PLANNING APPLICATION CONSULTATION RESPONSE

Application Number:	3/2022/0096
Proposal:	Demolition of former calf building, offices and retail units and construction of new building split into two units
Location:	Gisburn Auction Market, Gisburn, Lancashire

The Lead Local Flood Authority **maintains its objection** to the above application on the basis of:

Objection 1 – Inadequate Surface Water Sustainable Drainage Strategy

DRAINAGE ATTENUATION STORAGE

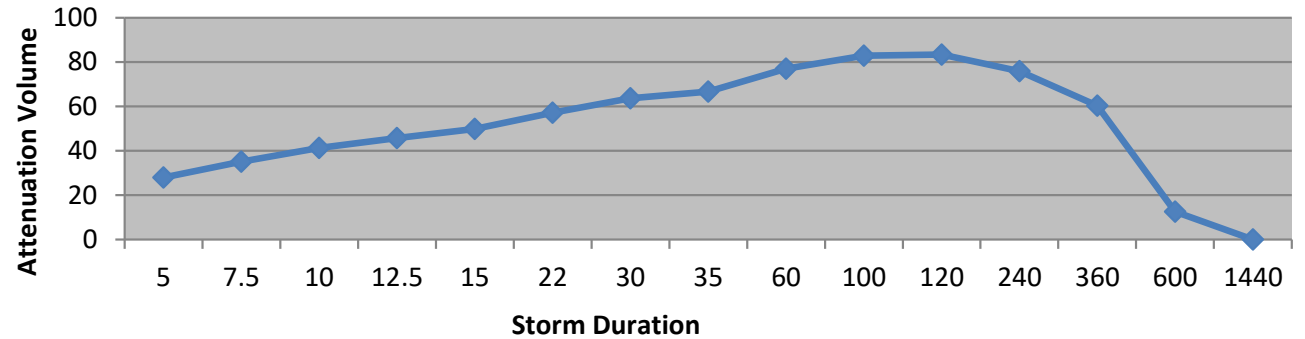
1. **Provide appropriate minimum operation standards for peak flow control**, in line with the Defra Technical Standards for Sustainable Drainage Systems, therefore, is contrary to paragraph 169 of the National Planning Policy Framework.

Standards S2 and S3 of the Defra Technical Standards for Sustainable Drainage Systems require applicants to demonstrate that post-development peak flows of any proposed development do not exceed existing pre-development surface water runoff rates for the 100% (1 in 1-year) and 1% (1 in 100-year) annual exceedance probability rainfall event.

The submitted surface water sustainable drainage strategy fails to contain peak flows within these parameters as evidence has not been provided to demonstrate how the peak runoff rate from the development to the surface water sewer for the 100% (1 in 1-year) annual exceedance probability rainfall event and the 1% (1 in 100-year) annual exceedance probability rainfall event will not exceed the peak greenfield runoff rate for the same event.

Historically, minimum discharge rates have been limited to 5l/s due to the risk of blockage of outlets with an orifice size of smaller than 50mm. However, using appropriate drainage and sufficient upstream treatment orifice sizes can be made larger with discharge rates being limited far below 5l/s without causing an unacceptable risk of blockage. Features such as permeable paving, trash screens, catchpit manholes and vortex flow control devices are example of SuDS components that are proficient in reducing the risk of blockages. As the DCG allows adoption down to a 50mm orifice, it is now generally felt that 2 l/s (which can be achieved with a vortex control regulator), is now an appropriate target for

the minimum flow rate. This should lead to appropriate selection of SuDS design which minimises the amount of solids (debris and sediment) in the flow. If all surface water first goes through features like permeable/porous paving then the majority of pollution and debris will be prevented from reaching the outfall, therefore discharge rates will be able to be lower than 5l/s.

Therefore, the proposals are contrary to Standard S2 of the Defra Technical Standards for Sustainable Drainage Systems. This is sufficient reason in itself for a refusal of planning permission.
